**KIRKLEES METROPOLITAN COUNCIL
INVESTMENT & REGENERATION SERVICE**

Reference No: 2021/62/92034/W

Site Address: 24, Rutland Road, Milnsbridge, Huddersfield, HD3 4RA

Description: Erection of single storey extension to rear and raised decking, demolition of existing conservatory and associated alterations

east elevation

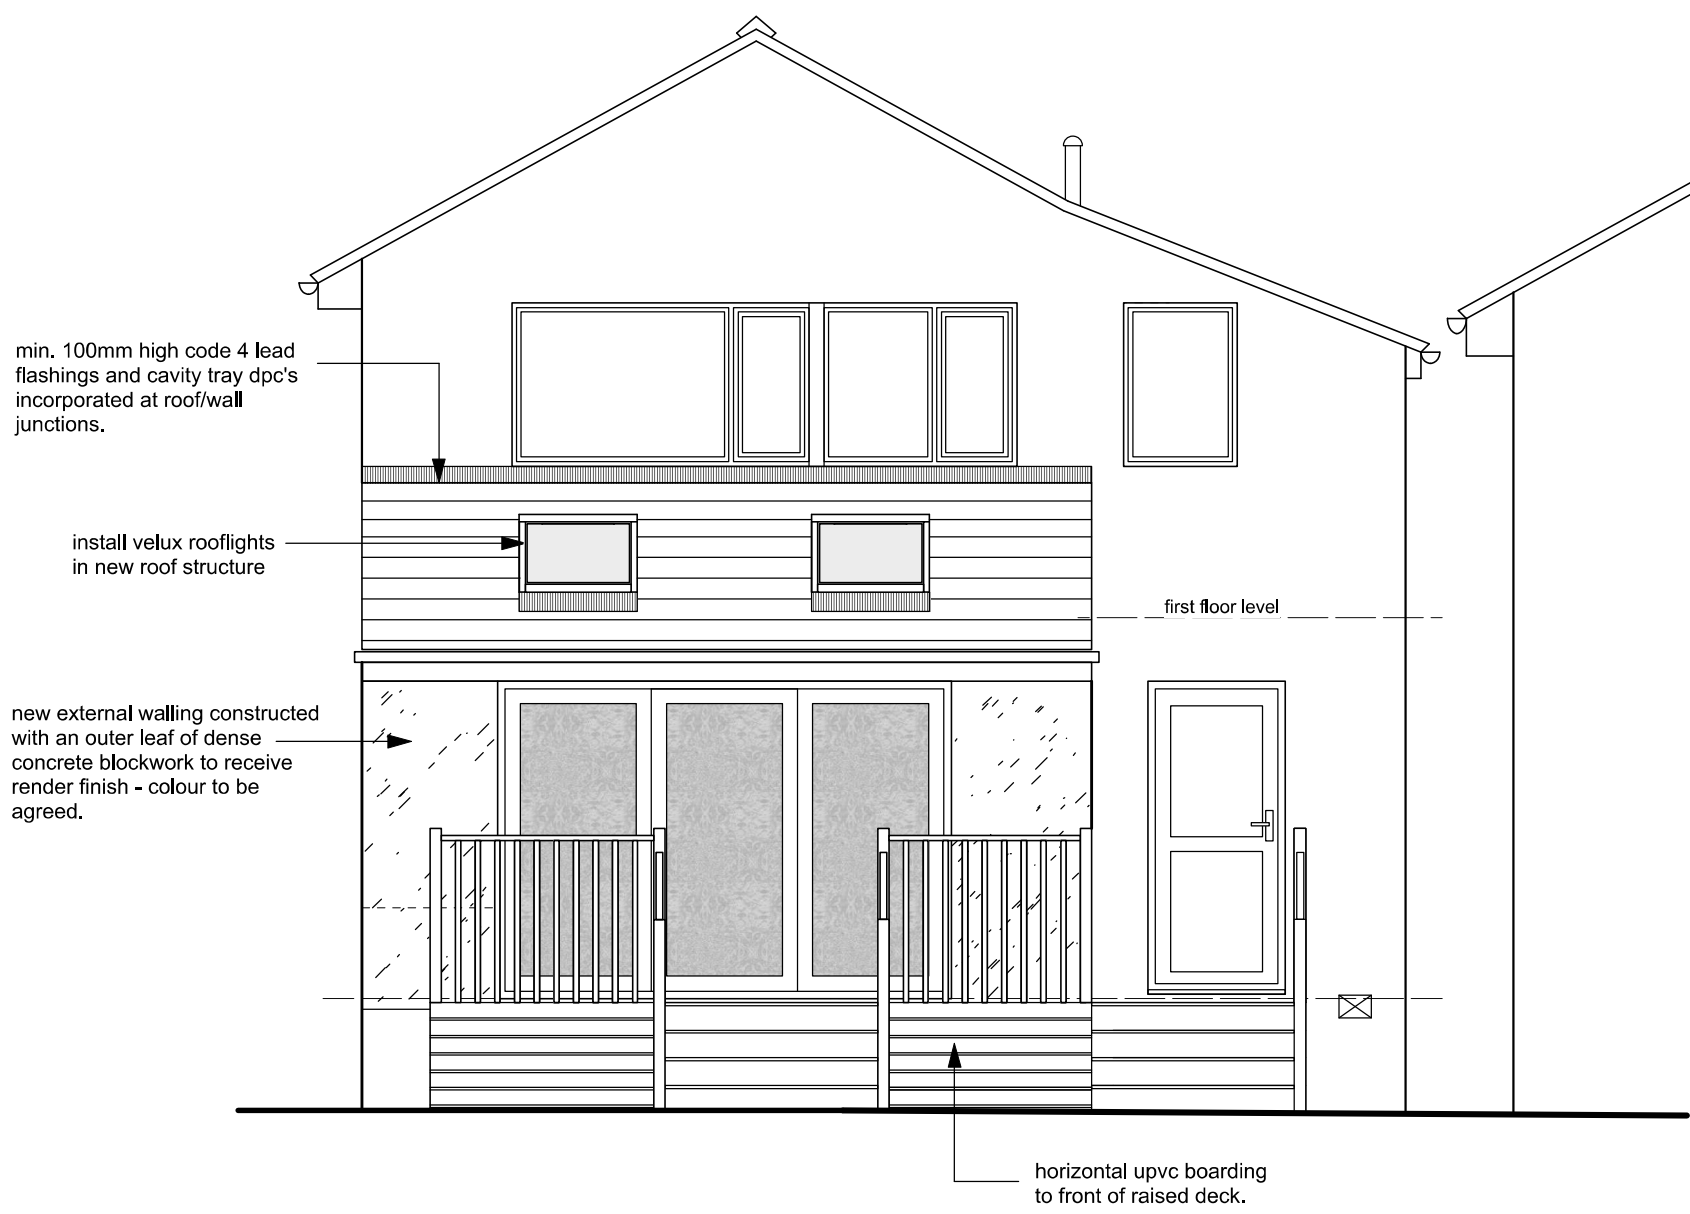
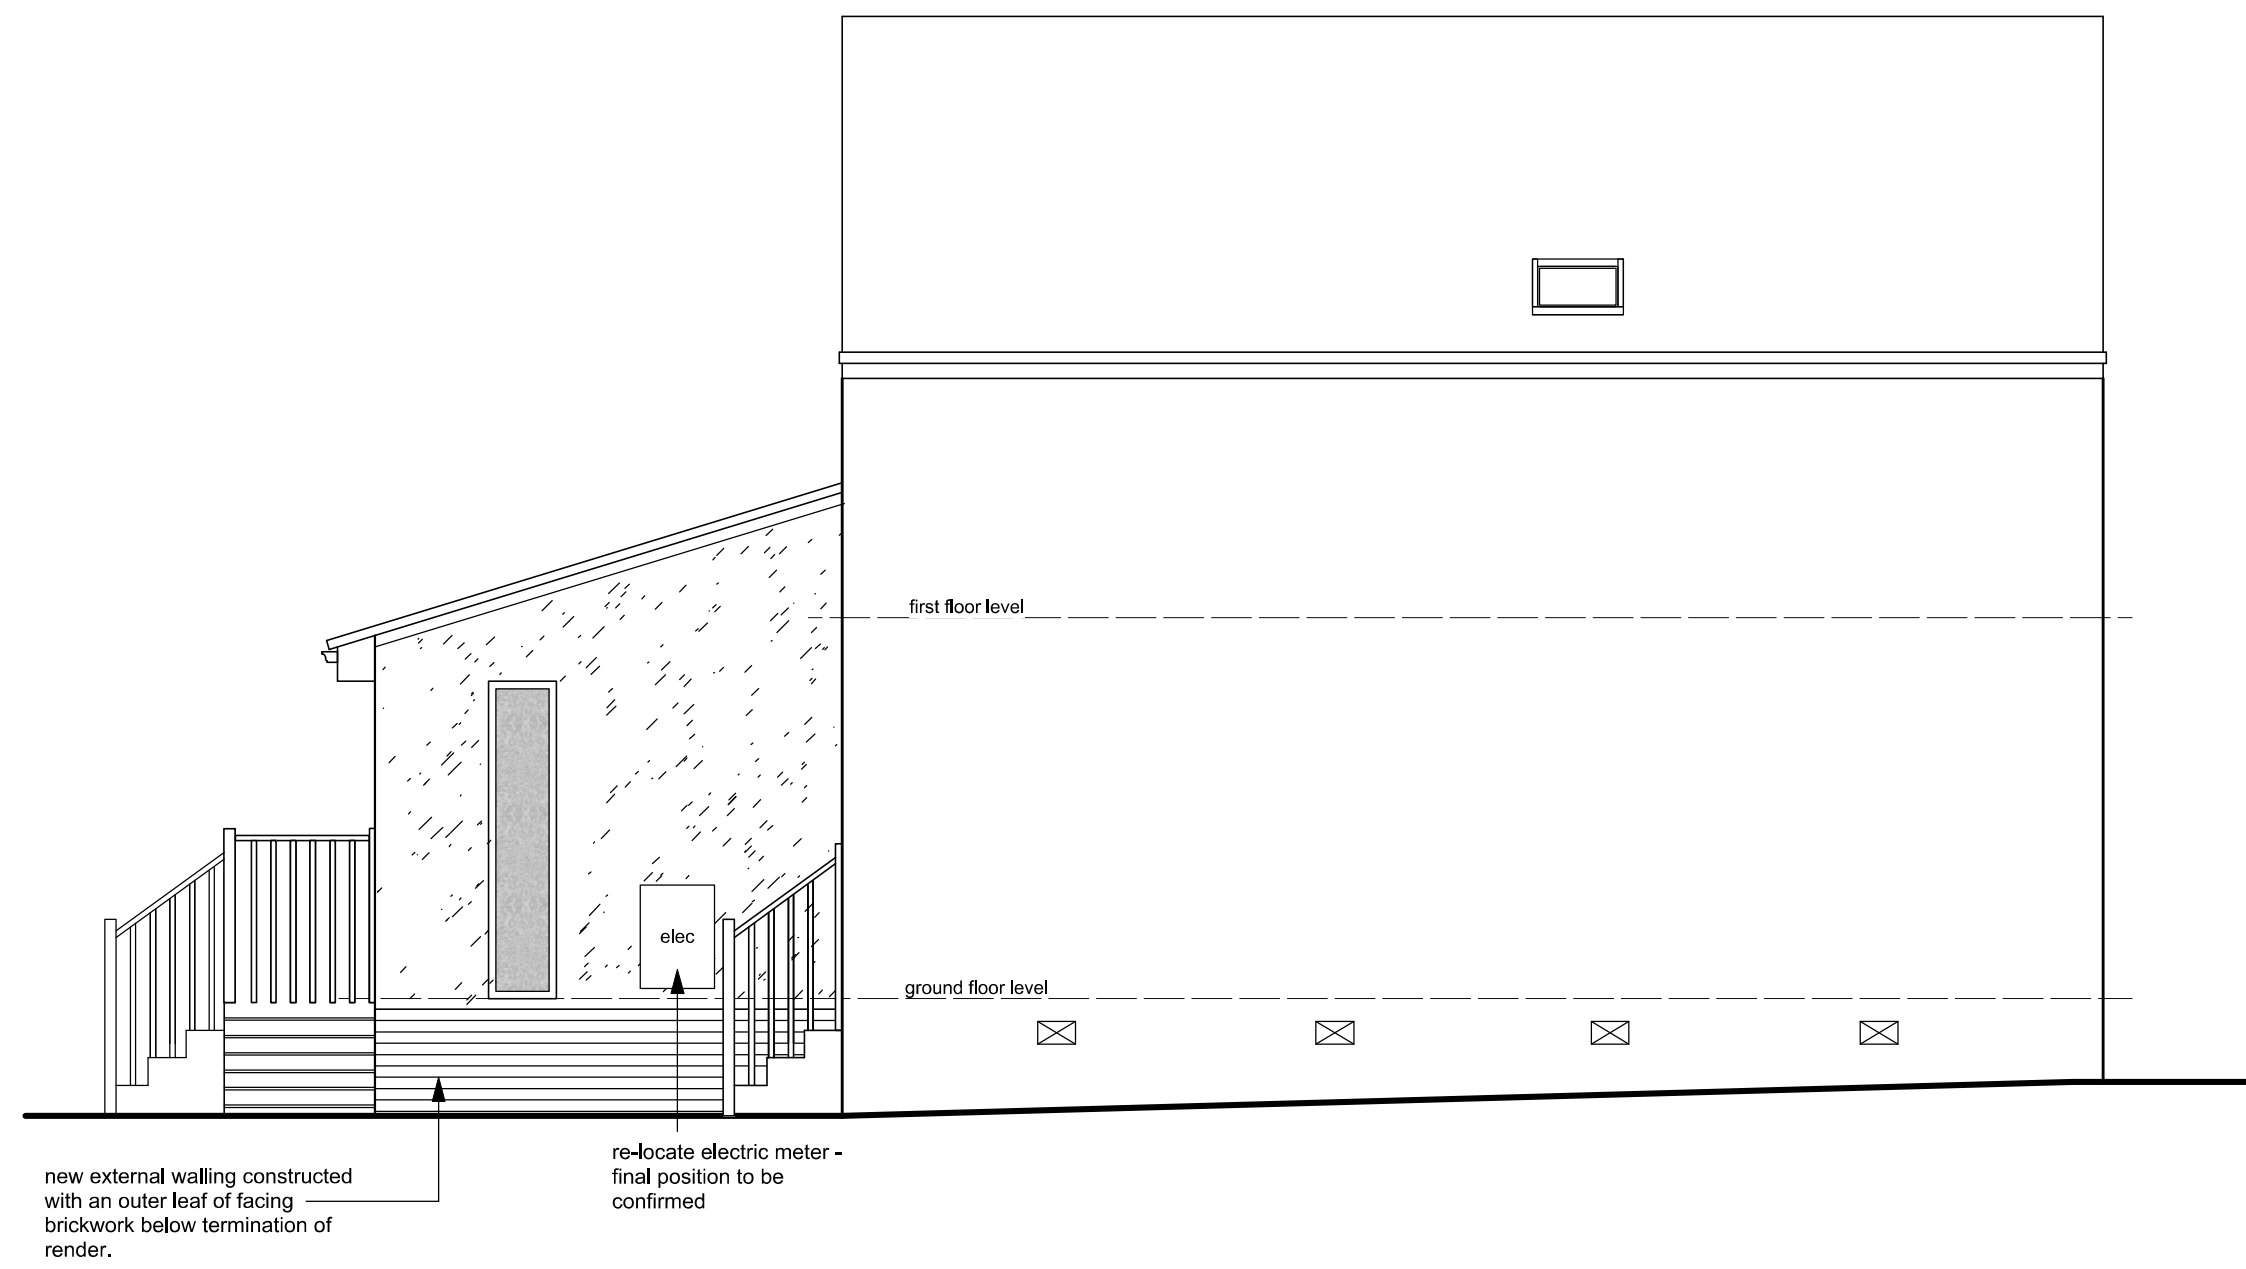
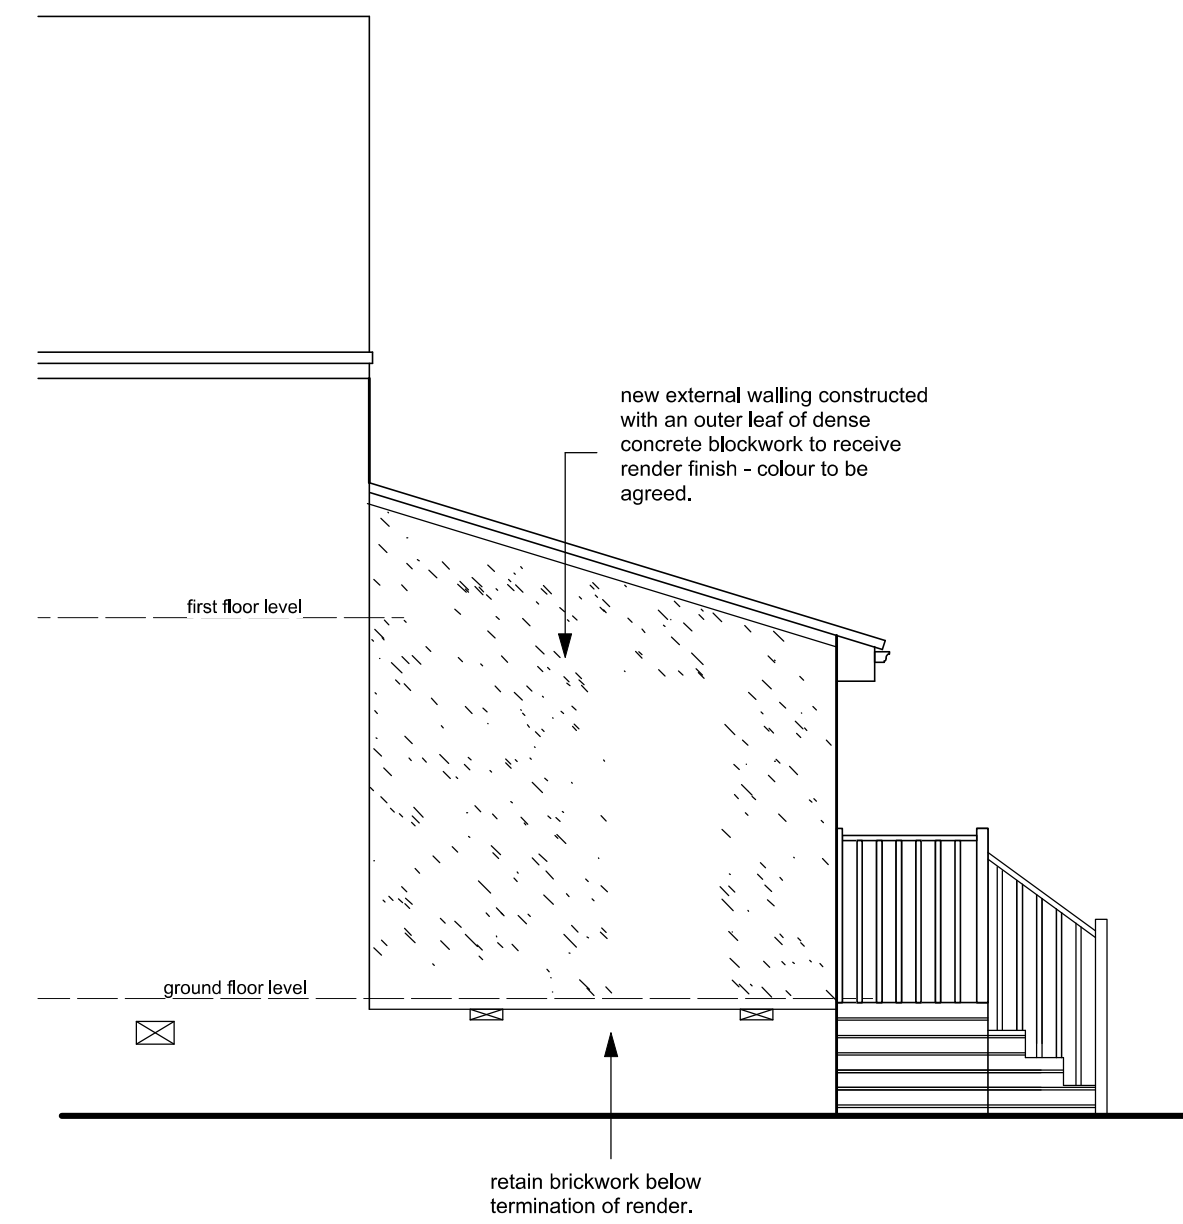
In this case there would be no windows in the side west facing elevation facing No.26, however the proposal shows a tall thin window in the east elevation facing No. 22, albeit the current conservatory has clear glazing facing the neighbours at No. 22, the new extension will be moved closer to the shared boundary and given the difference in levels would create overlooking at close quarters. Therefore, this window should be conditioned to be obscurely glazed to allow additional light into the room but to prevent overlooking of its neighbours. (condition 5)

5. The family room window in the side elevation of the extension hereby approved, shall be obscurely glazed (minimum grade 4), before the extension is first brought into use. Notwithstanding the provisions of section 55(2) (a) (ii) of the Town and Country Planning Act 1990 and the Town and Country Planning (General Permitted Development) Order 2015 (or any order revoking or re-enacting that Act or Order with or without modification) this window shall thereafter be so retained obscure glazed.
